Application Reference: 2026/62/90937/E

Site: Gomersal St Marys C of E First & Nursery School, Shirley Avenue, Gomersal, Cleckheaton, BD19 4NA

Proposal: Redevelopment of school, including demolition of existing buildings; erection of single storey building; external works including provision of hard and soft PE and play spaces; sub-station; associated landscaping; installation of temporary building during construction

Sport England Reference: PA/26/Y/KK/73632

DWG No. SRP1134-ONE-ZZ-XX-D-L-0007 REV P05

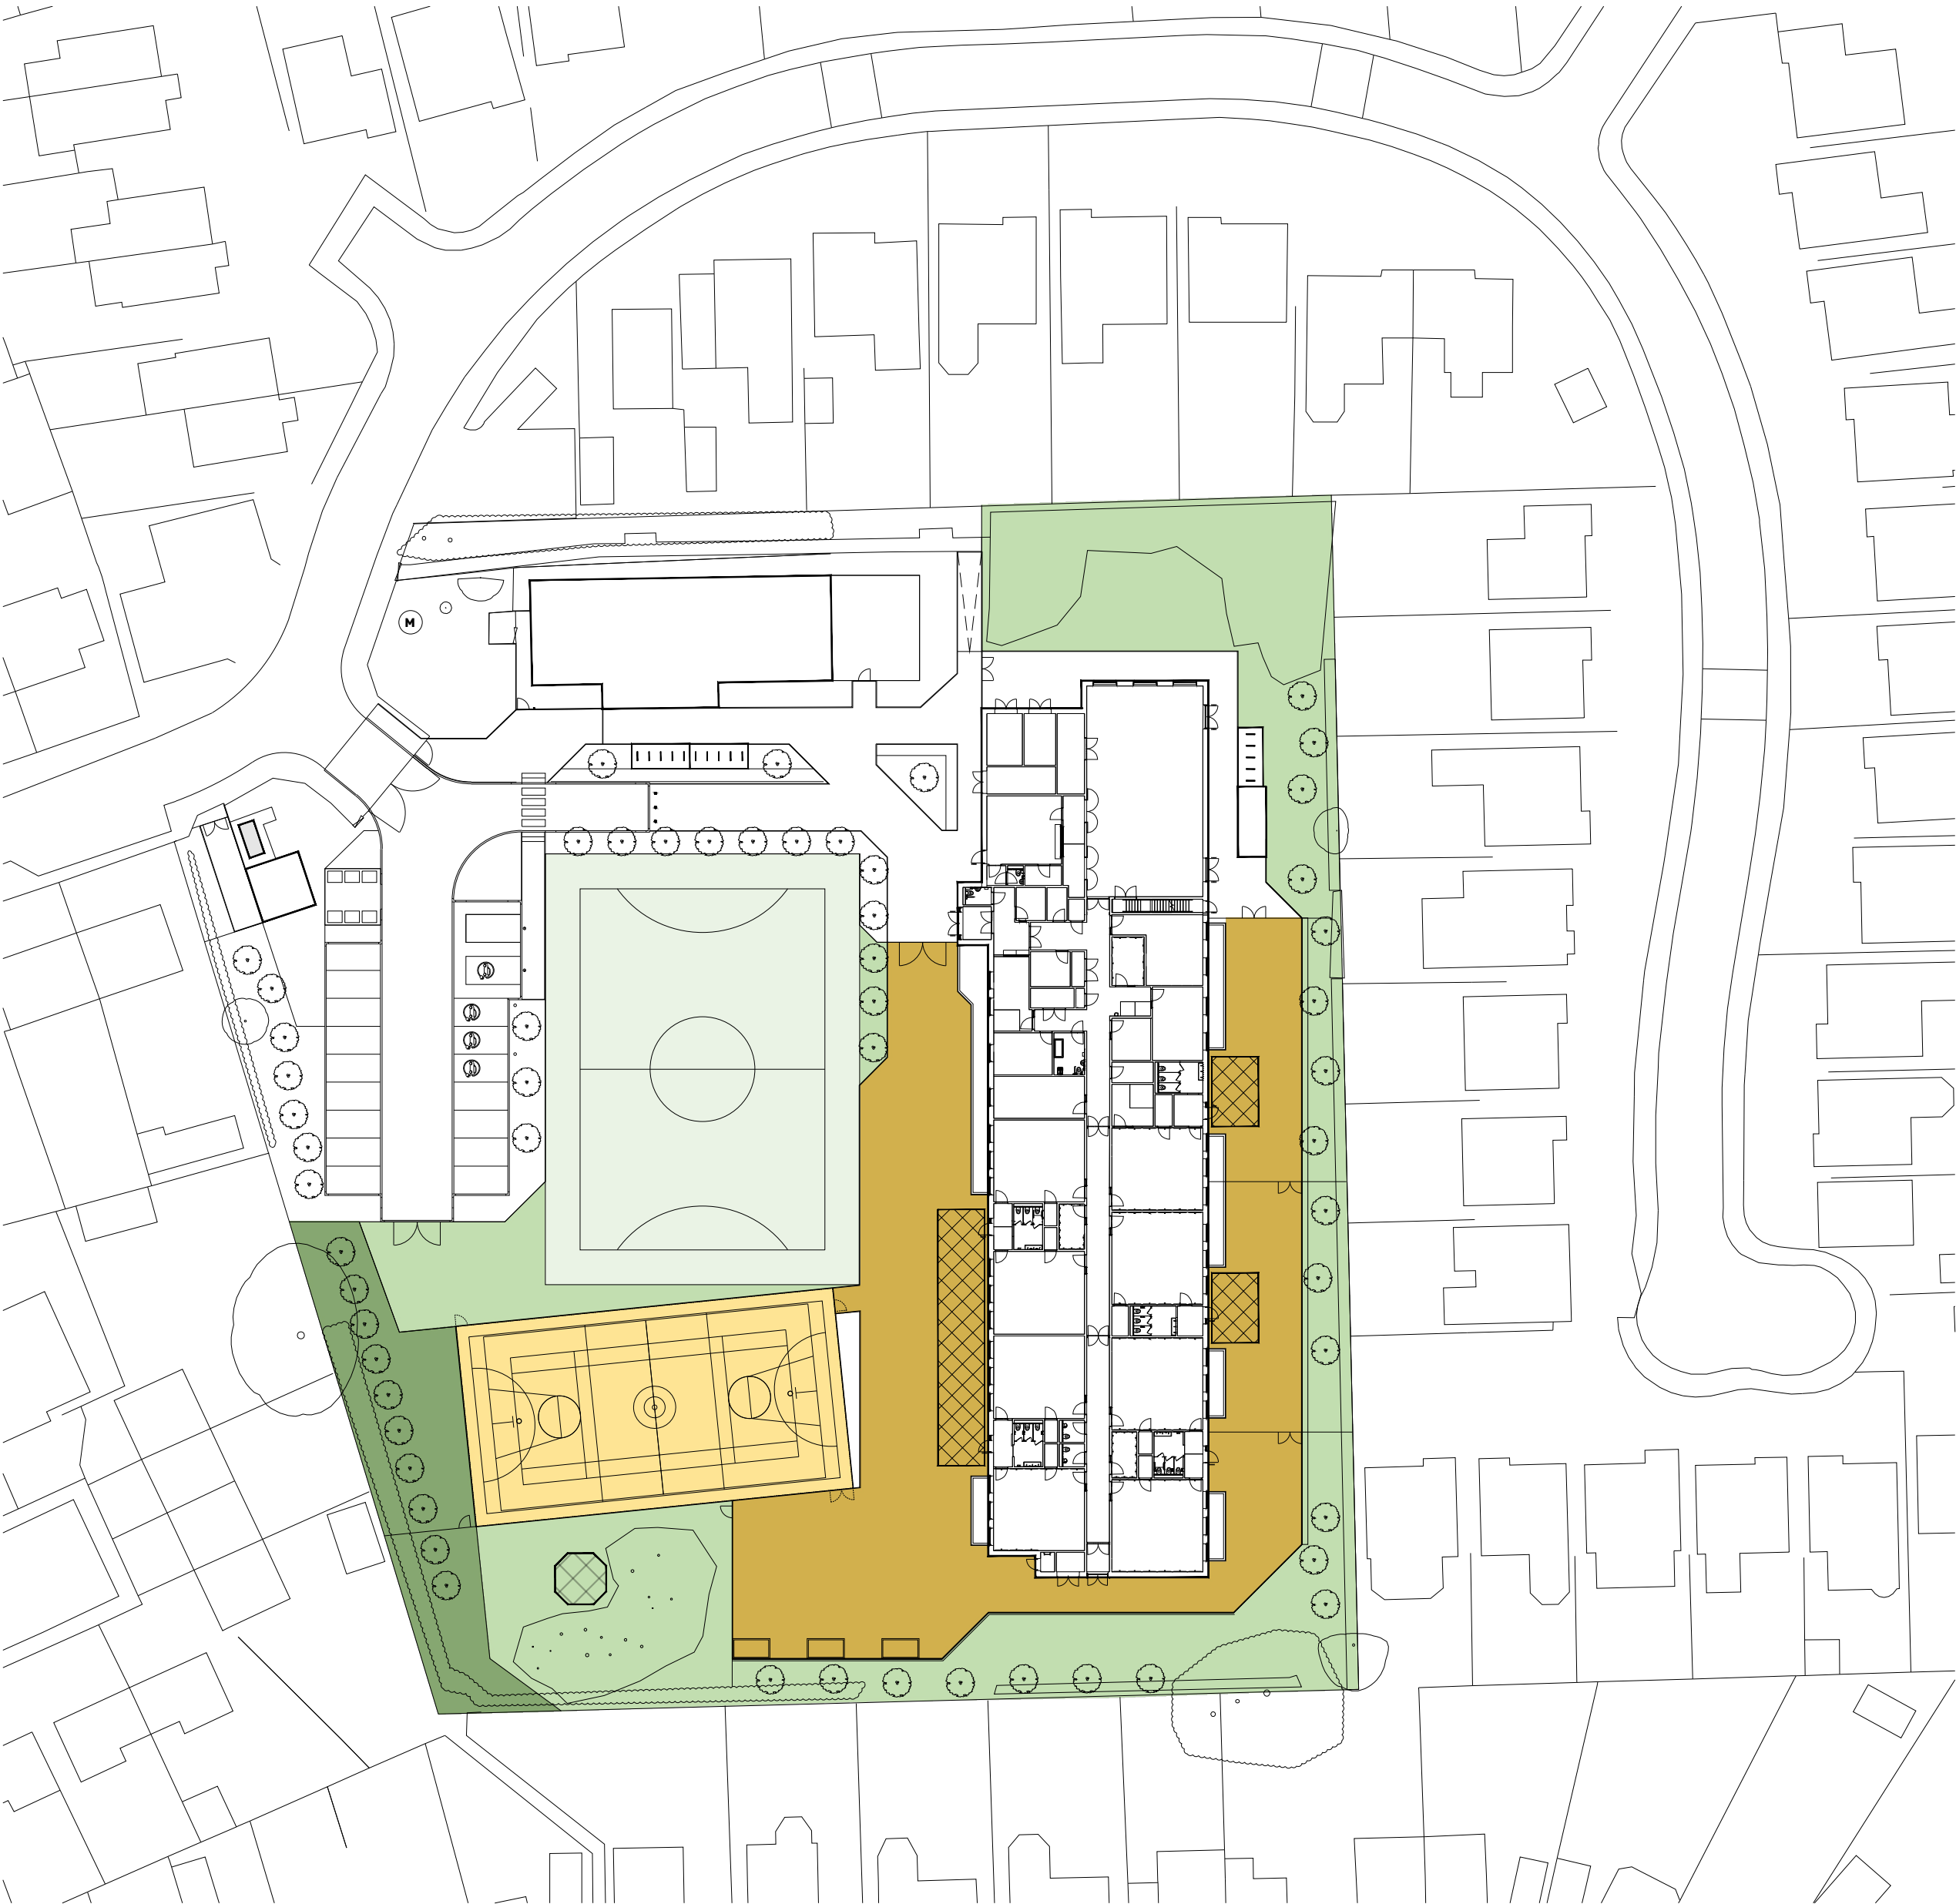
- Plans appear to propose marking out a “soft PE” area which would be suitable for recreational football. The soft PE area could not be used for affiliated matches, as it is not an FA recommended pitch size (measuring 30 X 21m), and the Football Foundation do not believe a Mini-Soccer U7 and U8 5v5 (43 x 33m including safety run-off area) would be able to be accommodated on site. Football Foundation do welcome that the pitch has safety runoffs of 3 metres, in line with FA technical standards.
- Provided clarity is given that football goals are still to be present on the playing field, the Football Foundation would consider plans to be an equivalent or better playing field for recreational football.

The proposal shows a ‘Soft PE’ area with line markings that appear to be for football (approximately 30 m × 21 m, with 3-metre safety run-off). As indicated by the Football Foundation, this area would only be suitable for recreational football due to its size. Additionally, a ‘Hard PE’ area (approximately 34.5 m × 19.2 m) with line markings for tennis, netball and basketball, together with associated safety run-off areas and enclosure, is shown. It is noted that historic Google aerial imagery suggests that the existing grass playing field has not had any pitch line markings or a dedicated formal facility for court sport. Therefore, it is considered that, subject to appropriate conditions, the proposed playing field could be of equivalent or better quality to that which is being lost.

That said, Sport England strongly encourages the applicant not to miss the opportunity to redesign the 'Soft PE' area so that it can accommodate a Mini-Soccer U7 and U8 5v5 pitch measuring 43 m × 33 m, including safety run-off. This would future-proof the proposal should the school decide to host football match play in the future. Furthermore, Sport England is of the view that there is sufficient open space within the site to reposition features to achieve this dimension.
